A19 Downhill Lane Junction Improvement

Scheme Number: TR010024

**7.18 Written Submission of Applicant's case
put orally at Issue Specific Hearing 2 on 16th
October 2019**

WRITTEN SUBMISSION OF APPLICANT'S CASE PUT ORALLY AT ISSUE SPECIFIC HEARING 2 ON 16TH OCTOBER 2019

## **APPENDIX D: COMBINED LAND ASSEMBLY PLAN**

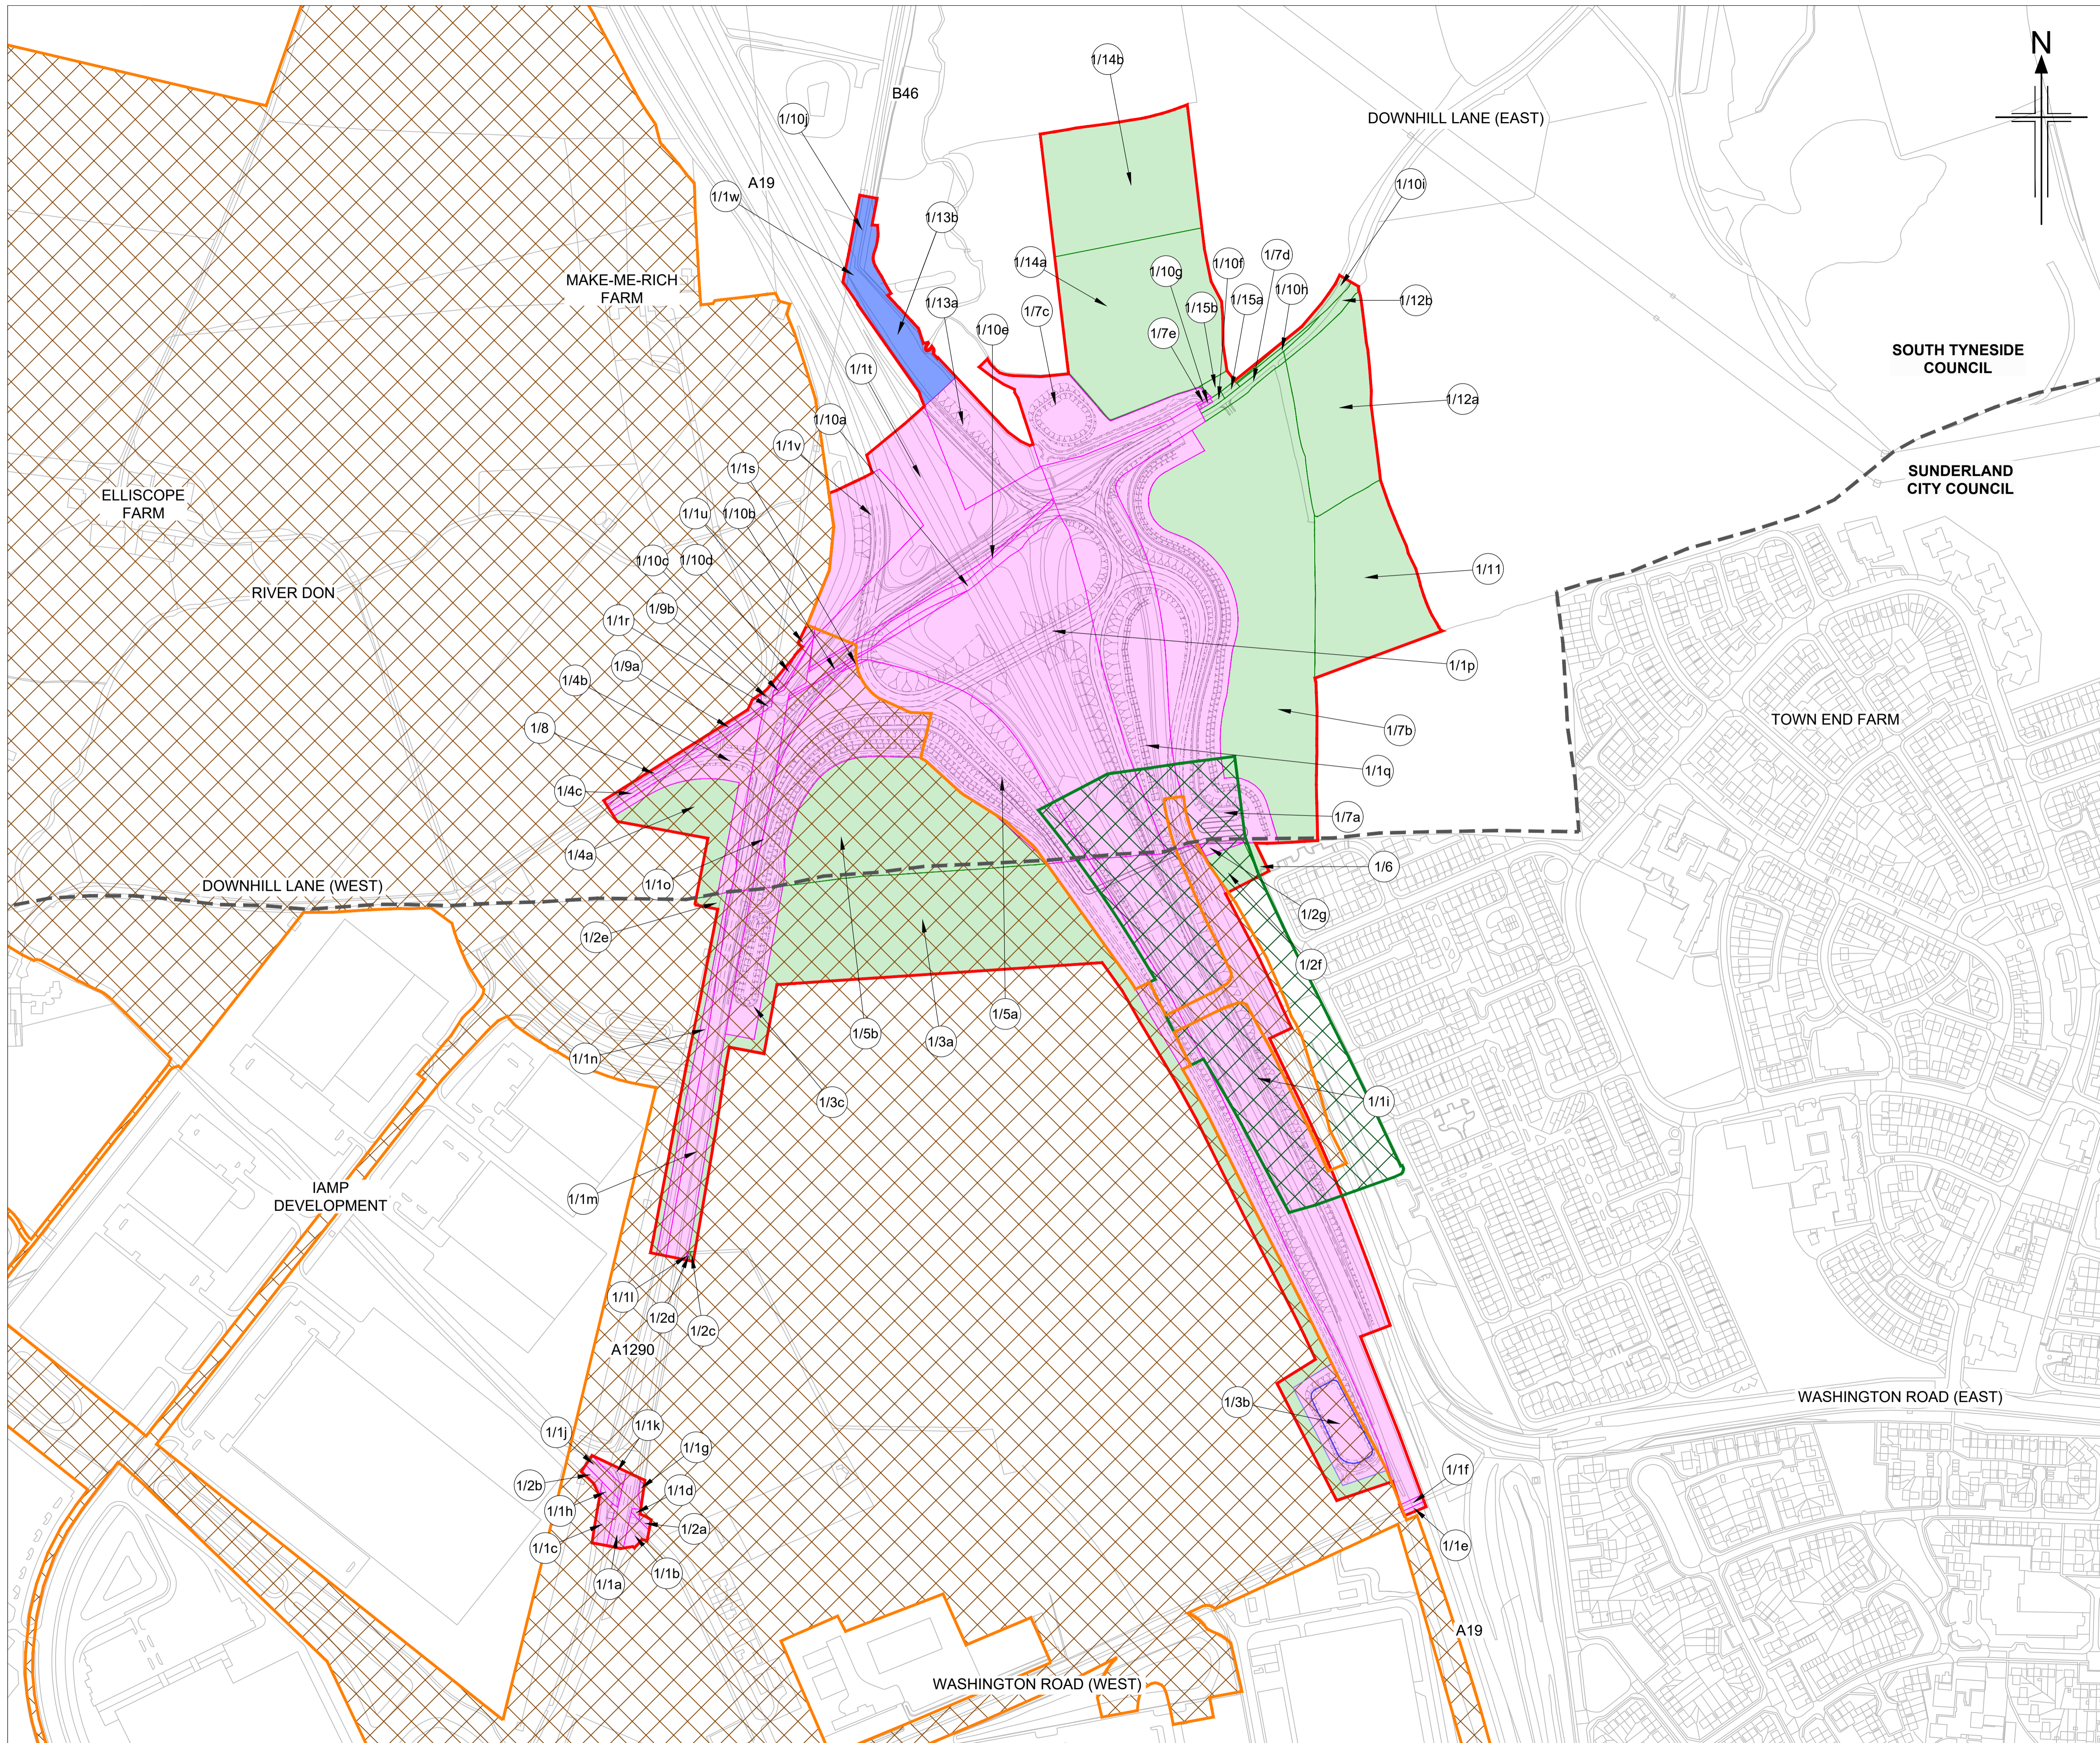
- 3.13 TH clarified the land references at paragraph 3.2.3 of the IRD by stating that the plans were appended. The ExA sought further explanation of the cross hatching on the plans at Appendix D as he wanted to understand what is required for IAMP TWO.

- 3.14 PE stated that the Applicant sought to use the most recent IAMP TWO consultation plan, and IAMP LLP have collaborated in the production of the IRD plan. The geometry of the highway has been designed so the two schemes can dovetail, and there are other overlaps at Washington Road. It is clear in the IAMP SoCG that the overlaps are understood and that the two parties are working together to address them. PE clarified that the pink area within the proposed IAMP TWO permanent land area bounded by the orange line is where the highways tie in. The green is temporary land.

3.15 TH emphasised that the next revision of the IAMP SoCG will address the Scheme overlaps and interface of the land, but that the ongoing discussions with IAMP LLP concern only minor residual matters. TH confirmed that paragraphs 3.2.5, 3.4.5 and 3.5.6 of the IRD address the same points with respect to land assembly.
